K/9/19/HH

Additional Comments

The proposed annexe is to be located in the grounds of the property known as Kingston Corner. Immediately to the south of the site is a Grade II Listed Building. This building is a former barn which has been converted into residential use. It is constructed from flint with a slate roof. The main elevation of the barn building retains an agricultural character and appearance, which is illustrative of its former use. The building is surrounded by modern development which has reduced its immediate setting to its private garden.

Drawing Title:
GA - Proposed Elevations

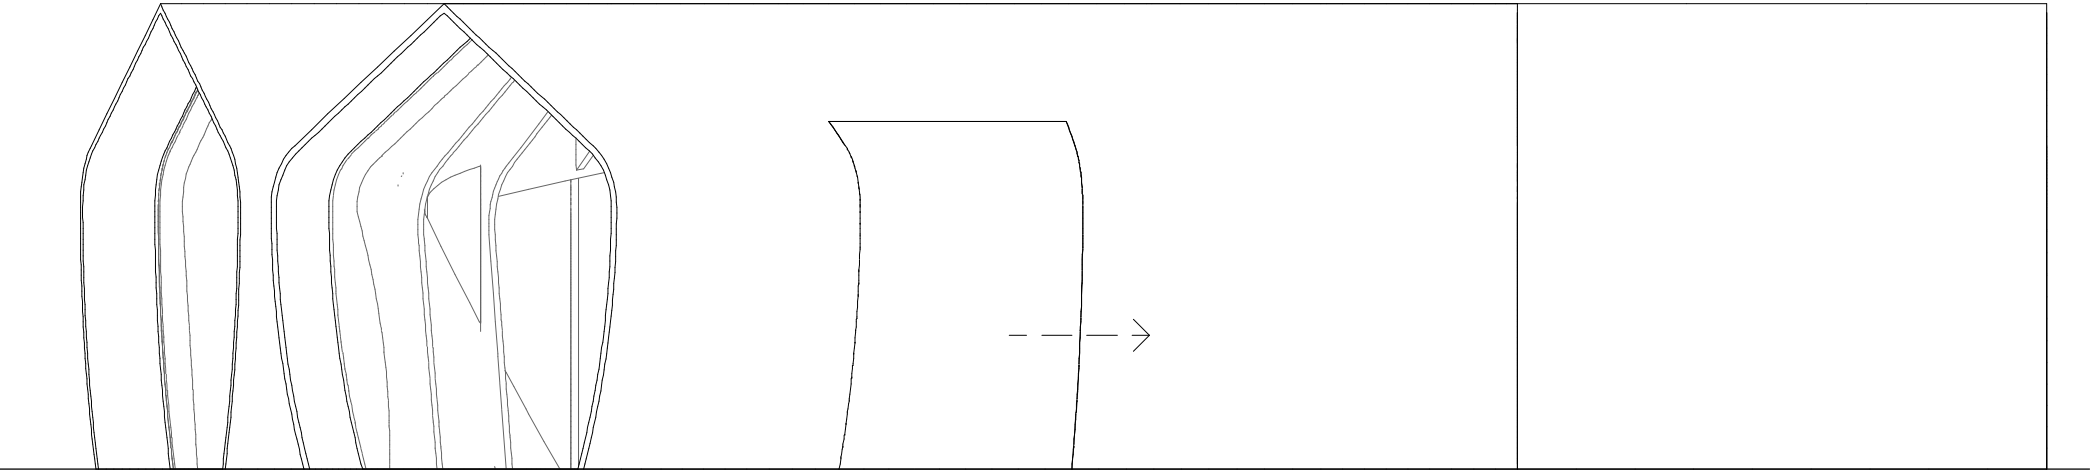
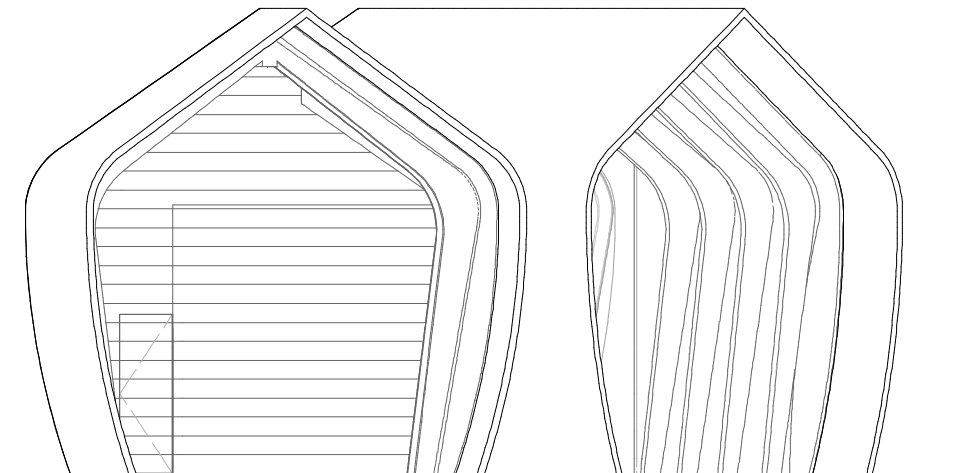
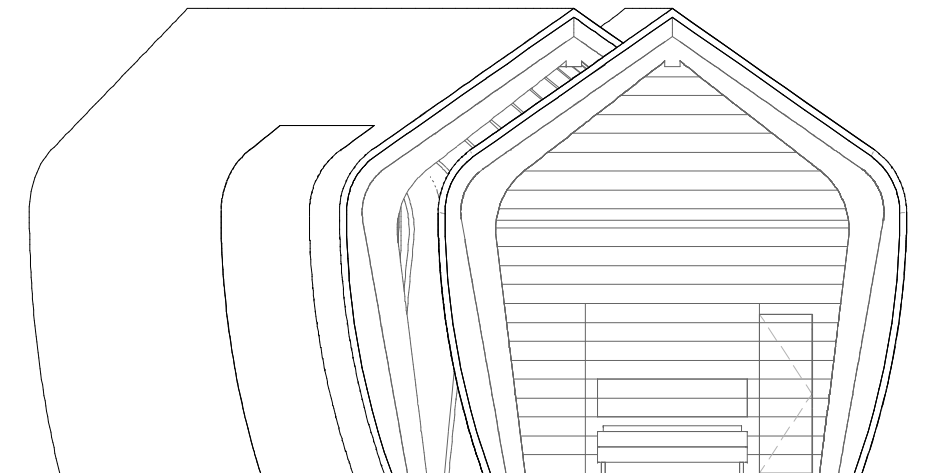
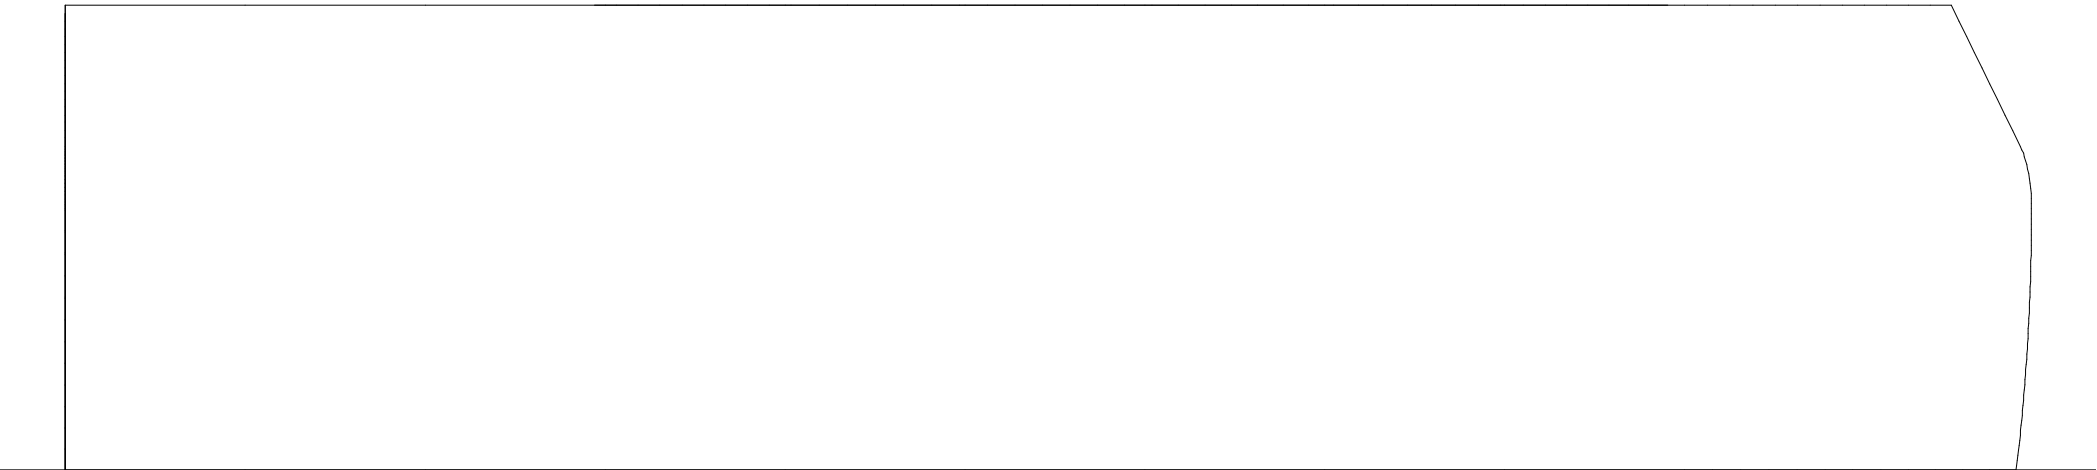
The annexe is substantial in size and of modern design/appearance. The location and the design of the building are considered to be acceptable; a modern, carefully thought-out building will reflect the varied character of the area. The only concern is the size of the building which will be approximately 6m high.

I note that there is a good amount of screening between the listed building and the application site. However, whilst tall, the height of this vegetation will mean that the top part of the annexe will still be visible when viewing the listed building (approximately 1.5-2m?). If this is the case, it will potentially be seen in the context of the listed barn.

Therefore, on balance, the proposal is such that the impact can be described as causing less than substantial harm in accordance with paragraph 196 of the NPPF (2018). The level of harm is considered to be on the lower end of the scale.
